7, Halliford Drive, Barnham

Single Storey Extension

Application No. ^{BN}WA/8/13/

Further to your letter dated the 8th April 2013 I enclose the following amended drawings as requested

GROUND FLOOR PLAN ~ AS PROPOSED.

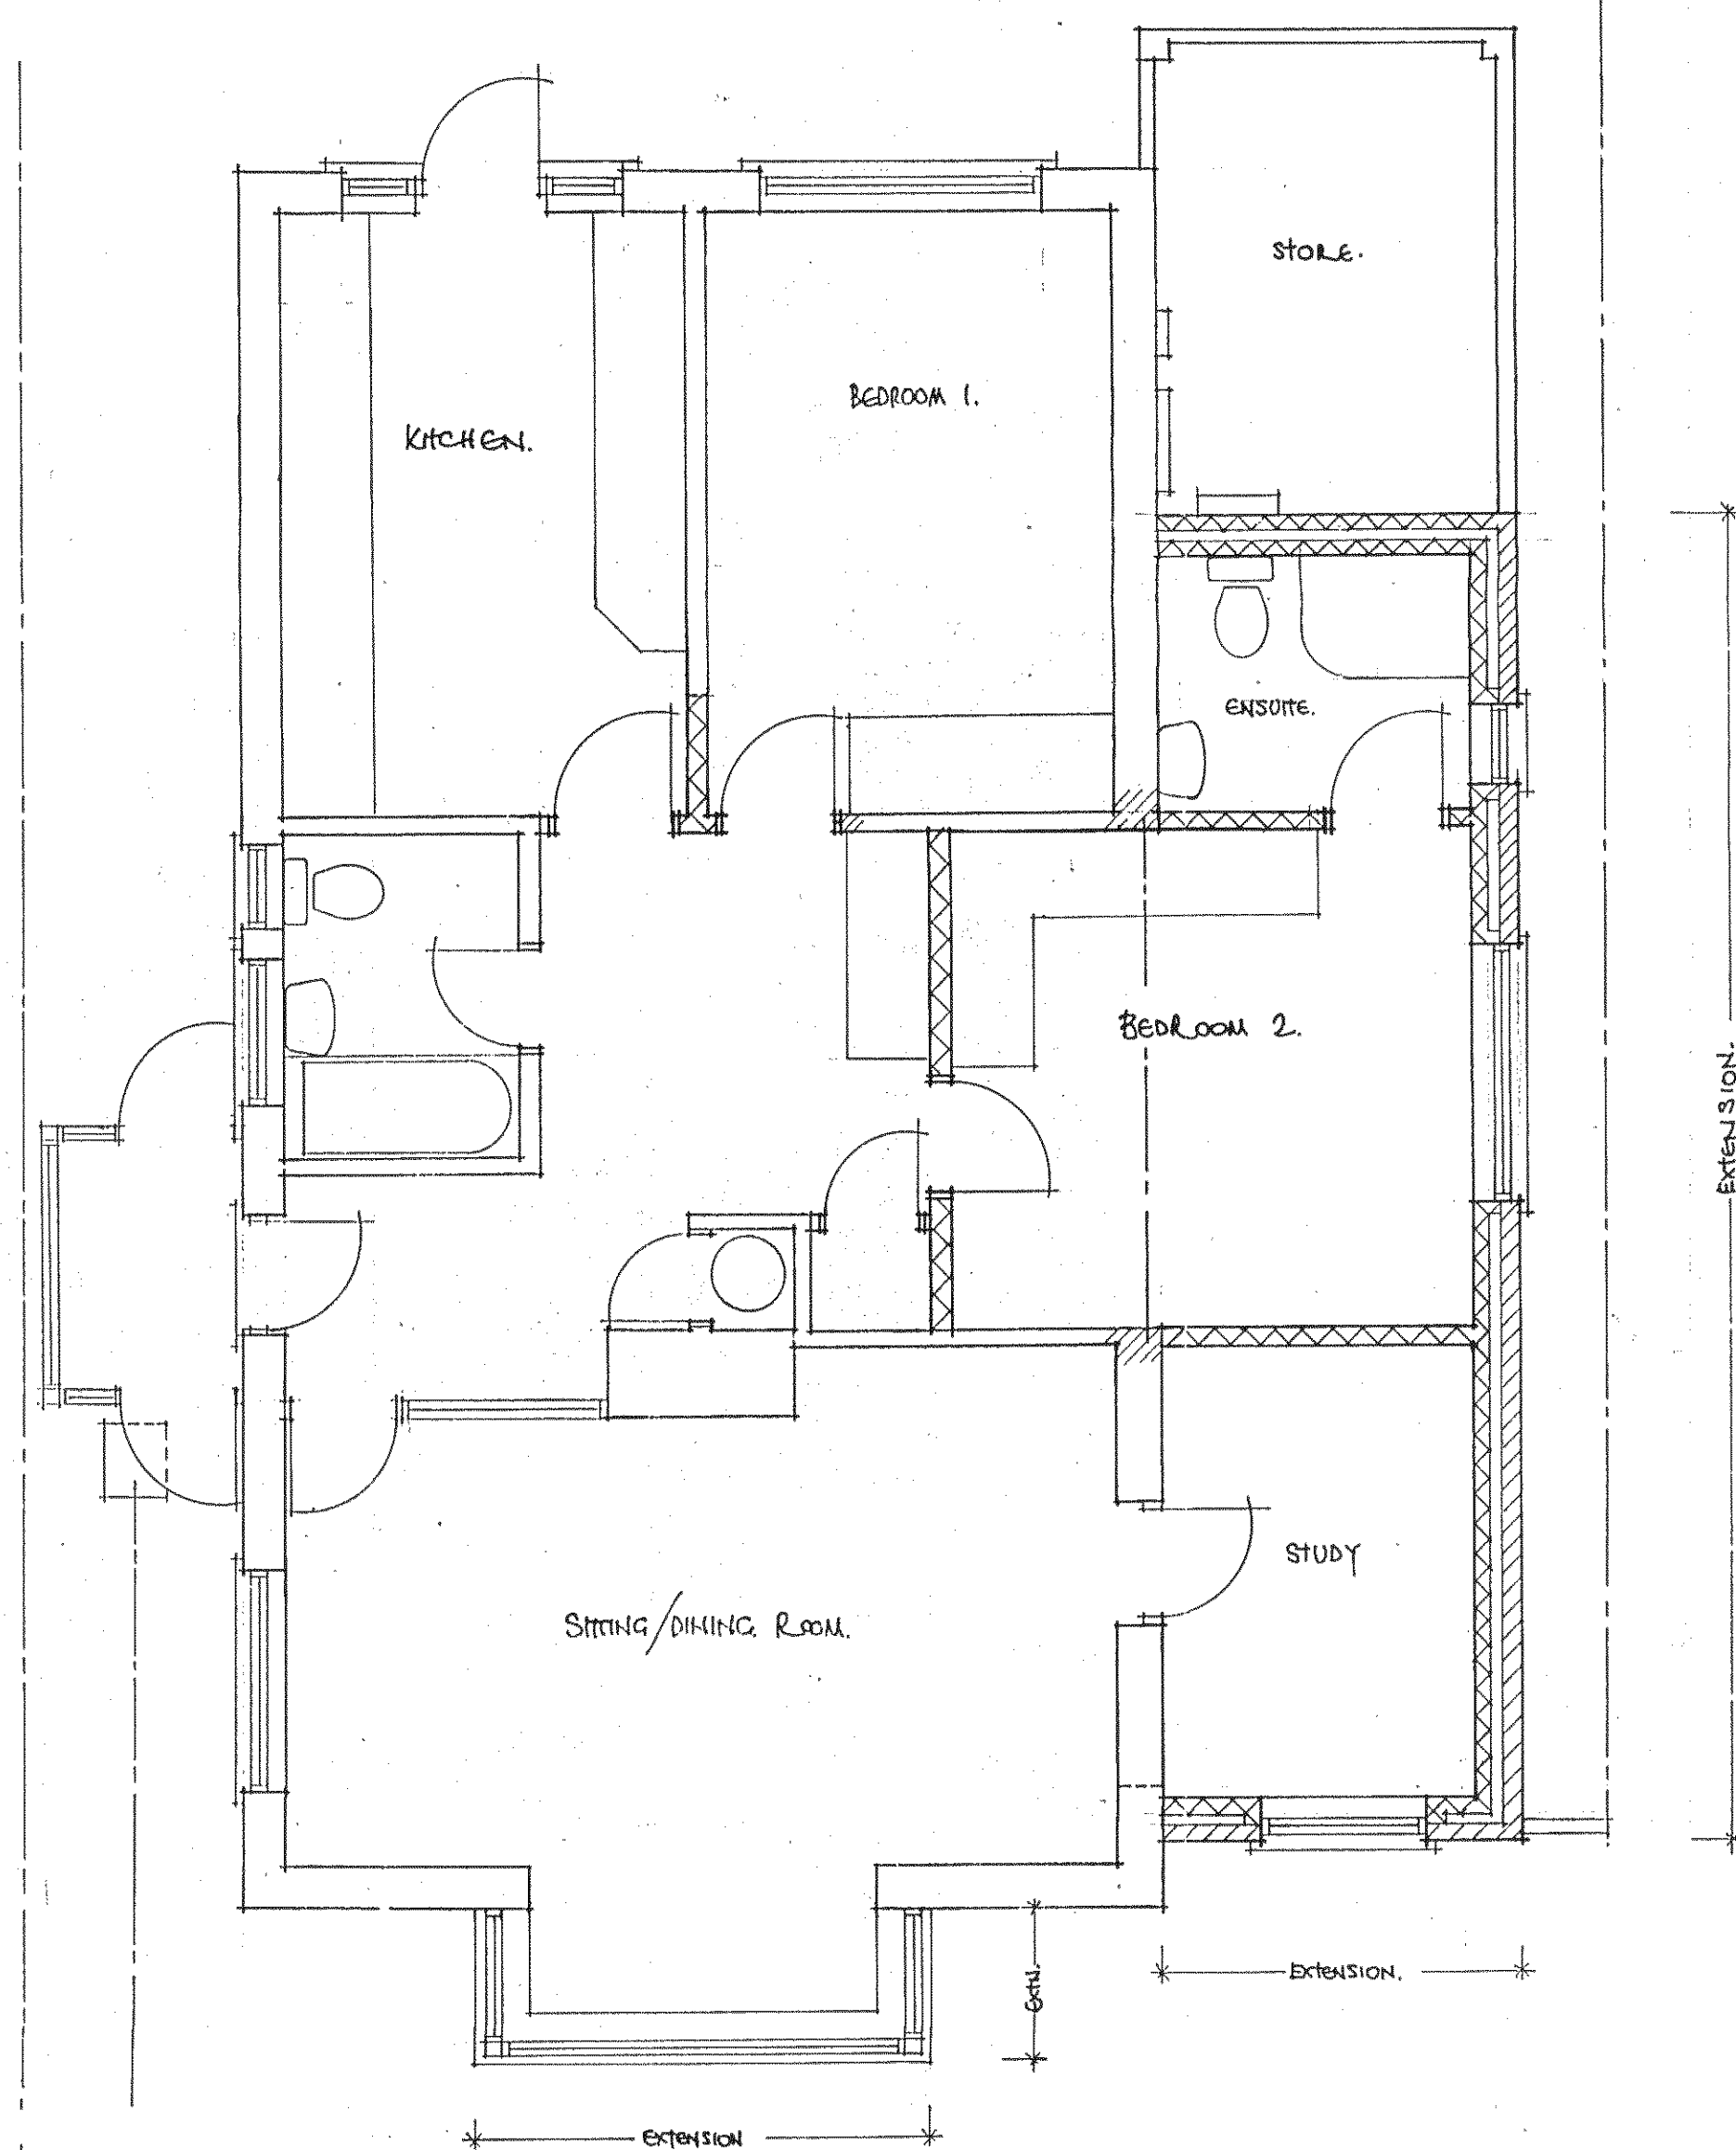
- 1) Two copies of the drawing No.98/13/02'A' showing the correct side elevation.
- 2) Having carried out a preliminary drain survey it has become apparent that it will not be possible to connect the new drains into the existing foul water drainage system in the normal way as the falls will not allow this, so it is our intention to install a 'saniflow' to serve the new ensuite facility & connect this into the existing foul water drainage system immediately outside the existing bathroom/WC,
